**WELWYN HATFIELD BOROUGH COUNCIL – DEVELOPMENT MANAGEMENT**  
**DELEGATED REPORT**

<b>APPLICATION No:</b>	<b>W6/2012/0766/EM</b>
------------------------	------------------------

The application seeks consent for the erection of a single storey rear extension.

**Site**  
1 : 1250

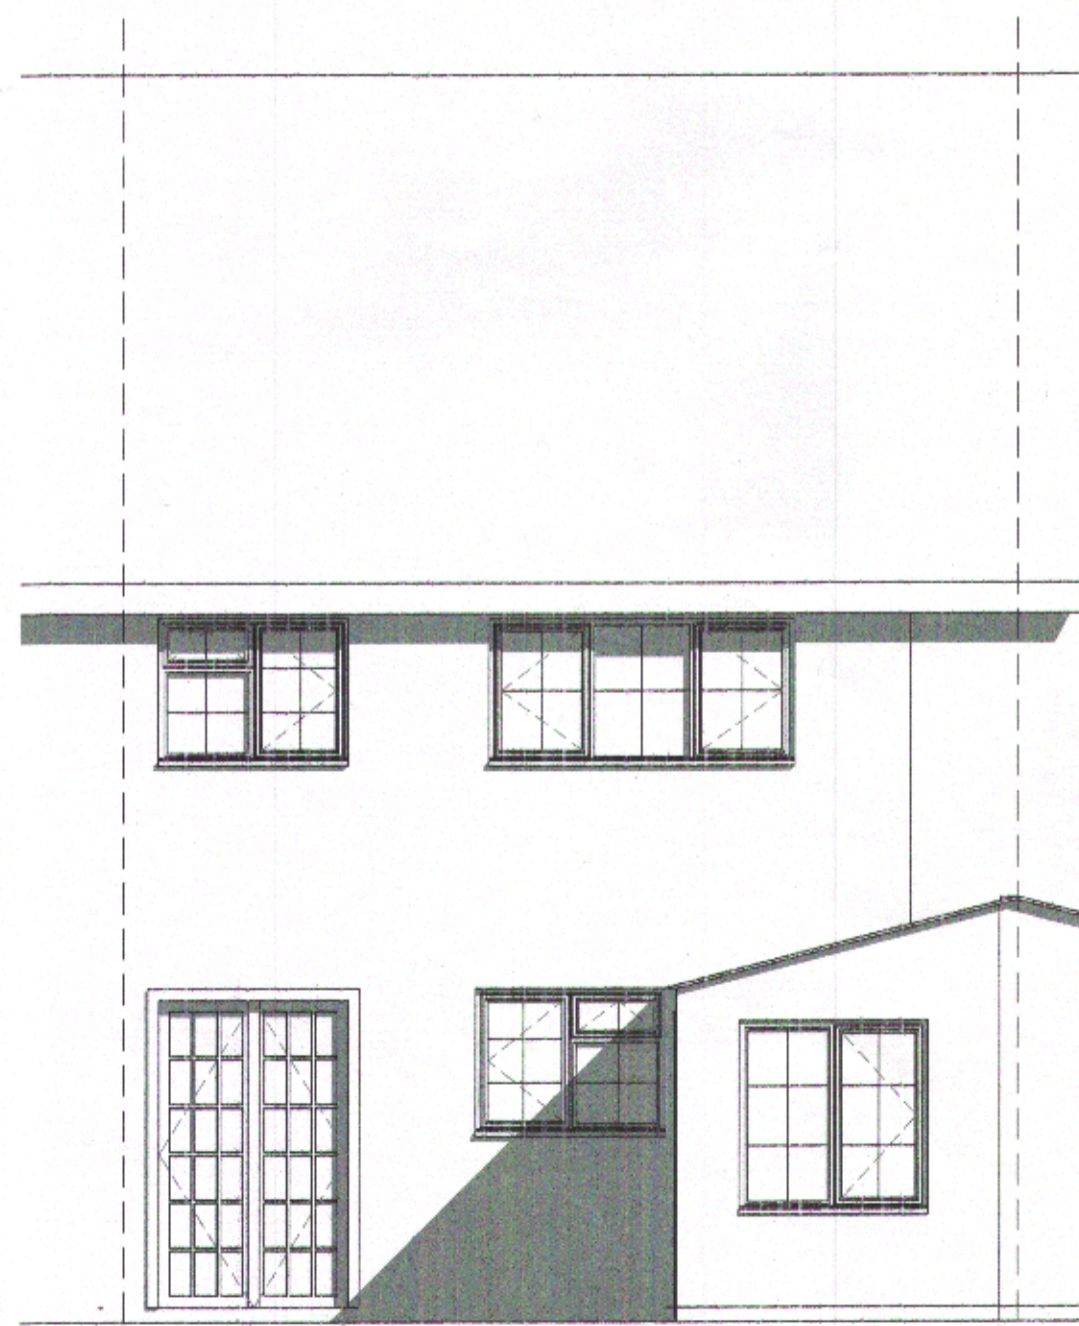
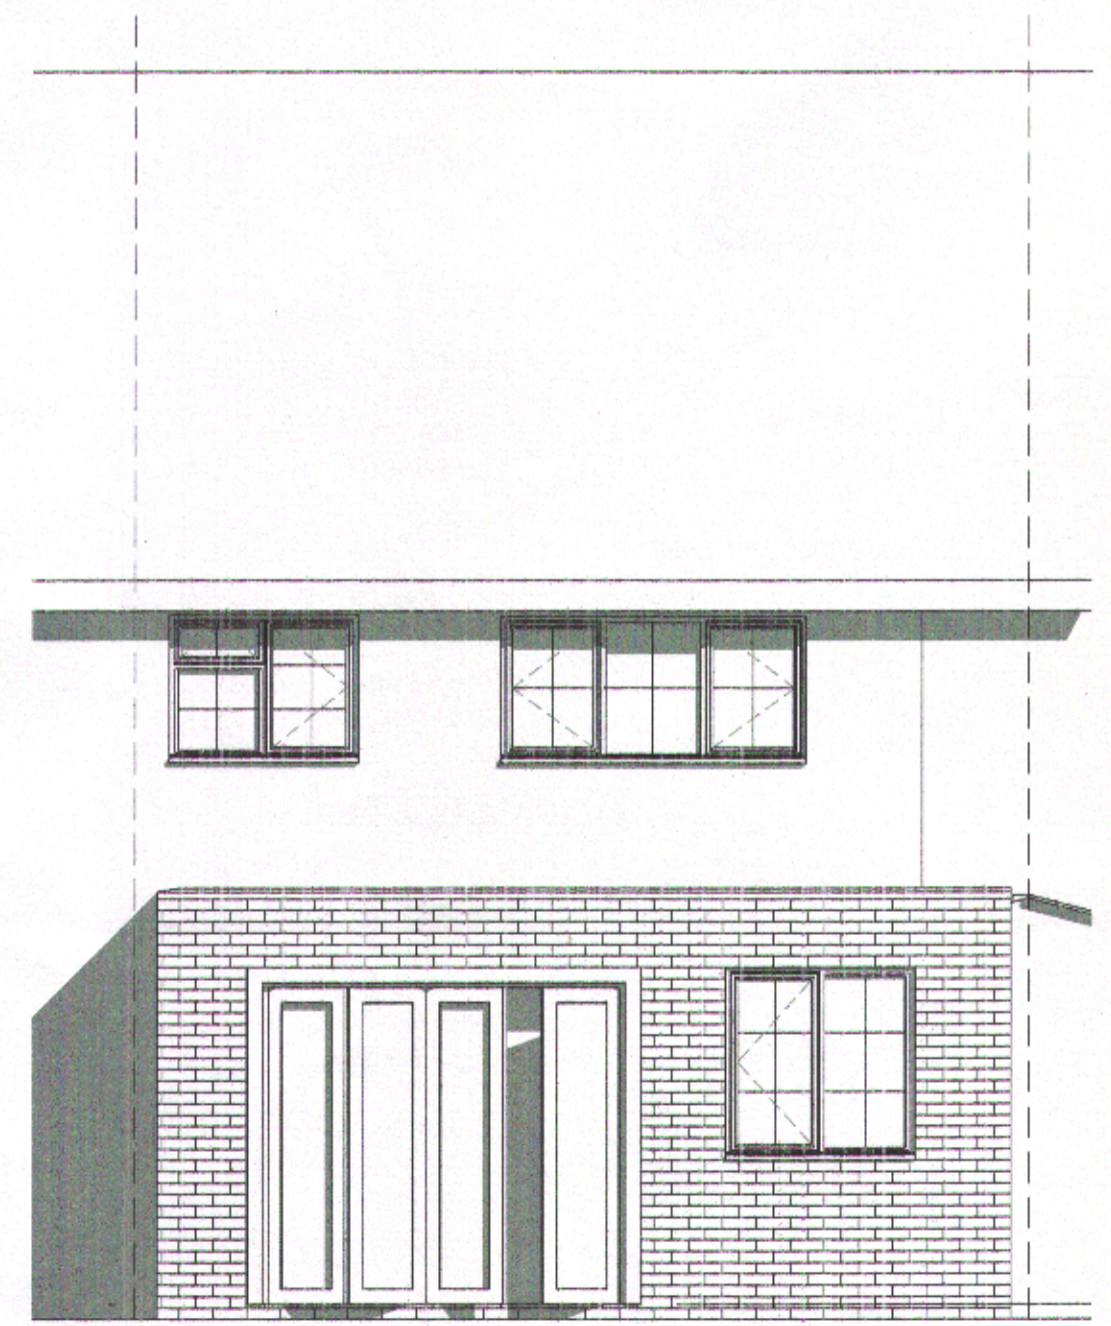
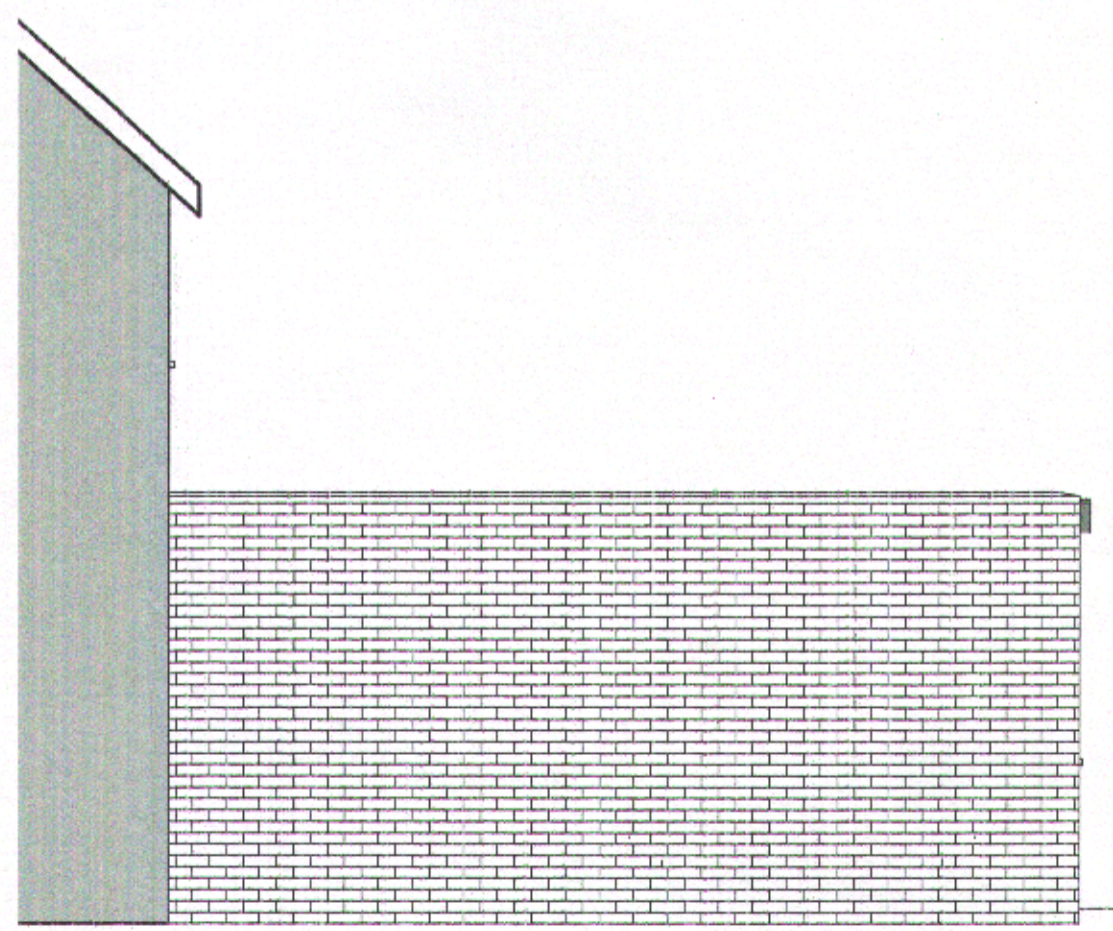
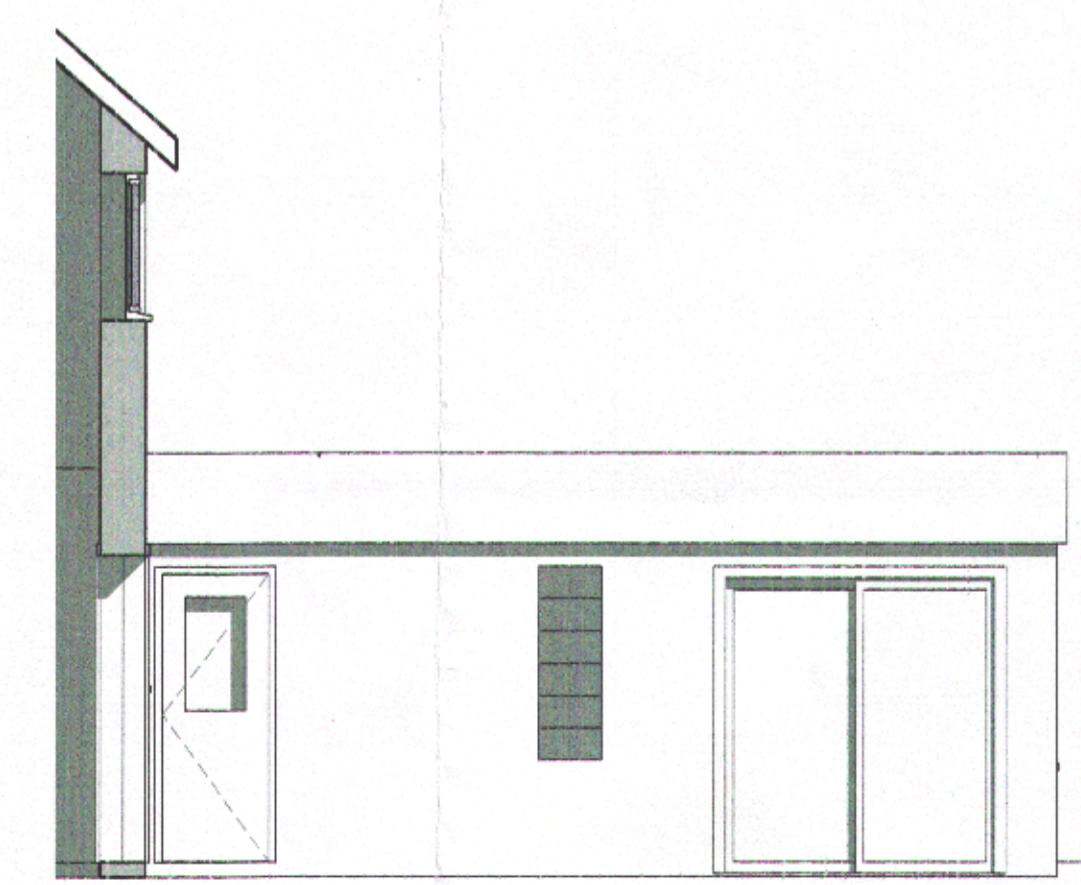
The property is a mid terrace dwelling in a row of four. The property has an existing single storey rear extension alongside the boundary with No. 175 which is the same depth as the extension proposed. This only has a width of approximately 2.3m. The proposed development seeks to form an extension which would extend basically across the full width of this dwelling for a depth of approximately 6m. As a result of the size, design and location deep into the garden, the proposed new development would be excessively large and would not appear subordinate in scale to the original dwelling. It would stand out amongst the surrounding back gardens as an unduly bulky and alien feature when viewed from the nearby properties. Consequently the proposed development would detract from the value and amenities of the garden city, contrary to the Policy EM1.

With regard to its detailed design and appearance, it has been designed with a flat roof which is characteristic of the garden city. It would be constructed from materials to match the existing and the fenestration, whilst not entirely reflective of the fenestration in the existing dwelling, given its location at ground level no objections are raised.

With regard to No. 179 Parkway, this property has a small rear extension which projects into the garden by about 2m. Given the depth of the proposed extension, which would be about 6m, it is considered that whilst there would be a limited loss of light given the height and siting of the extension, it is considered that it would project unduly into the rear garden and would appear overbearing and unduly prominent

from the rear of No. 179 Parkway to the detriment of the residential amenity of the occupiers of this property.

The proposed development would result in an excessive depth of built form from the original rear wall of the property which would fail to remain subordinate in scale to the original form of the property. In addition, the proposal would appear intrusive and overbearing from the rear of no. 179 Parkway to the detriment of the residential amenity that they should reasonably expect to enjoy.

1. The proposed extension, by virtue of the amount, scale, bulk, depth and design of development proposed would not be subordinate to the original dwelling and would result in an incongruous addition that fails to be in keeping and respect the original dwelling. The proposed development would therefore fail to preserve the unique architectural heritage of the building and would detrimentally impact on the amenities and values of the surrounding area contrary to the principles and policies of EM1 of the Estate Management Scheme.
2. By virtue of the location, depth and height of the proposed extension, it would appear visually intrusive and overbearing to the windows and private rear garden at No.179 Parkway to the detriment of the residential amenity of the occupiers of this property. The proposed development would therefore be contrary to Policy EM1 of the Estate Management scheme.
